Your Ref: CM/48/21/RES

Date 8<sup>th</sup> September 2021

### **RE: Land to the West of Church Lane South of Horsemere Green Lane Climping**

Revision N
Project Land at Climping Littlehampton
Title Site Plan
Dwg# 20.050.02
Status Planning

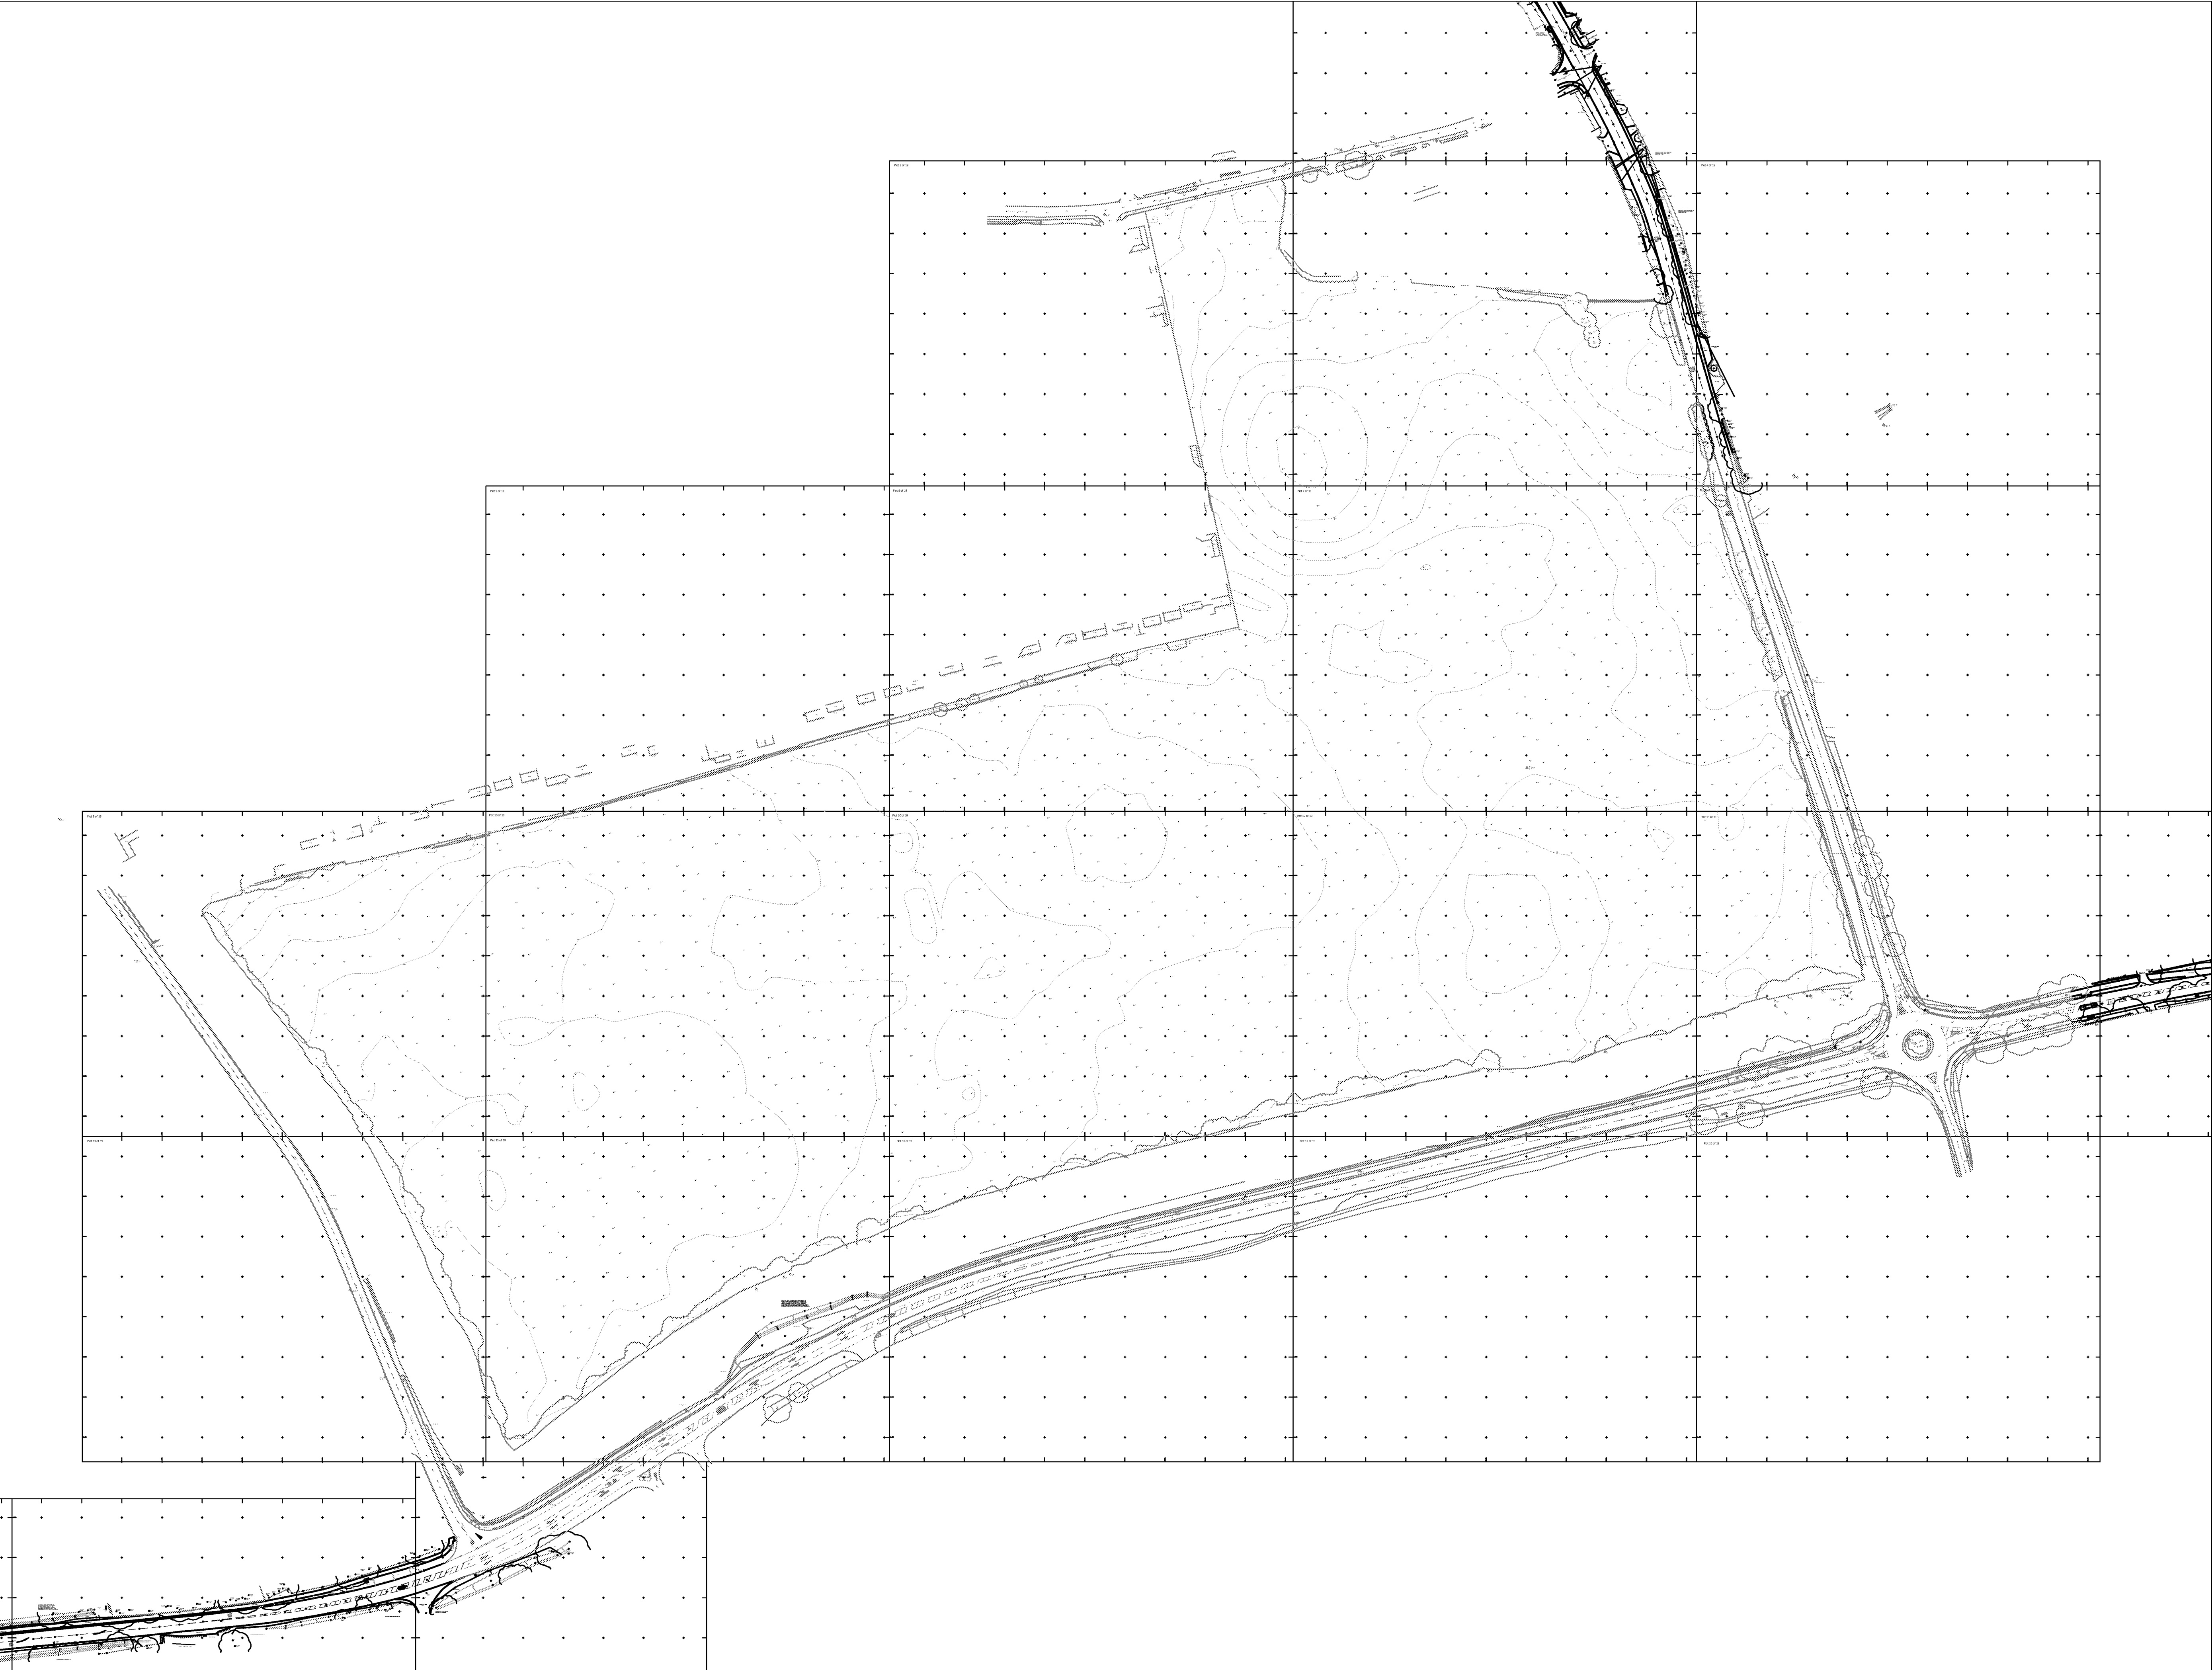
The orientation of the dwellings will ensure that all publicly accessible areas benefit from overlooking and good natural surveillance.

Where communal parking occurs, it is important that they must be within view of an active room within the property. An active room is where there is direct and visual connection between the room and the street or the car parking area. Such visual connections can be expected from rooms such as kitchens and living rooms, but not from bedrooms and bathrooms.

In relation to the apartments within the development it will be imperative that access control is implemented into the design and layout to ensure control of entry is for authorised persons only.

Additionally, I recommend the postal arrangements for the apartments is through the wall or externally mounted secure post boxes. I strongly urge the applicant not to consider letter apertures within the apartment's front doors. The absence of the letter aperture removes the opportunity for lock manipulation, fishing and arson attack and has the potential to reduce unnecessary access to the block.

With regards to the LEAP and LAPS within the development - areas of play should be situated in an environment that is stimulating and safe for all children, be overlooked with good natural surveillance to ensure the safety of users and the protection of equipment, which can be vulnerable to misuse. They should be designed to allow natural surveillance from nearby dwellings with safe and accessible routes for users to come and go. Boundaries between public and private space should be clearly defined and open spaces must have features which prevent unauthorised vehicular access. I would ask that these areas are surrounded with railings with self-closing gates to provide a dog free environment.

In relation to landscaping - I recommend that ground planting should not be higher than 1 metre with tree canopies no lower than 2 metres. This arrangement provides a window of observation throughout the area.
